COUNTY COUNCIL'S RESPONSE TO CONSULTATION ON THE FOLLOWING DEVELOPMENT PROPOSAL

Application no: 19/01047/OUT

Proposal: Outline planning application for a residential development of up to 850 dwellings; green infrastructure including formal (playing fields with changing rooms, allotments) and informal open space, landscaping; and associated infrastructure including a balancing pond; on land off the A4260, with access off the existing Longford Park access off the A4260 (Oxford Road), and a new access off the A4260 (Banbury Road). All matters of detail reserved, save for access.

Location: Land North East Of Oxford Road West Of Oxford Canal And East Of Bankside Banbury

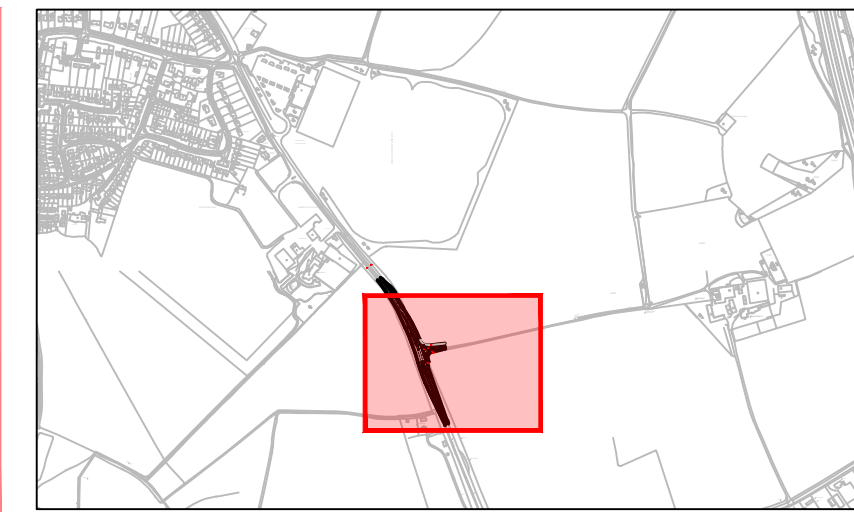
The drawing submitted with the application (16052-01-124 Rev B) does not show visibility splays at this junction, nor forward visibility to the traffic signal heads on the approaches to the junction. This is particularly important given the bend in the road and changes in vertical alignment of the A4260 just to the west of the junction.

The length of the required visibility splay at the site access and of the forward visibility to the signal heads must be informed by the current 85th percentile speeds

at this location, in accordance with standards set out in the DMRB. This must be based on current traffic speeds as the TRO required for the extension to the 40mph restriction will be subject to statutory consultation and so cannot be predetermined. Vehicle tracking for coaches, large refuge vehicles and emergency vehicles making turning movements to / from the access junction in all directions is required to demonstrate that these vehicles can safely access the site at this junction.
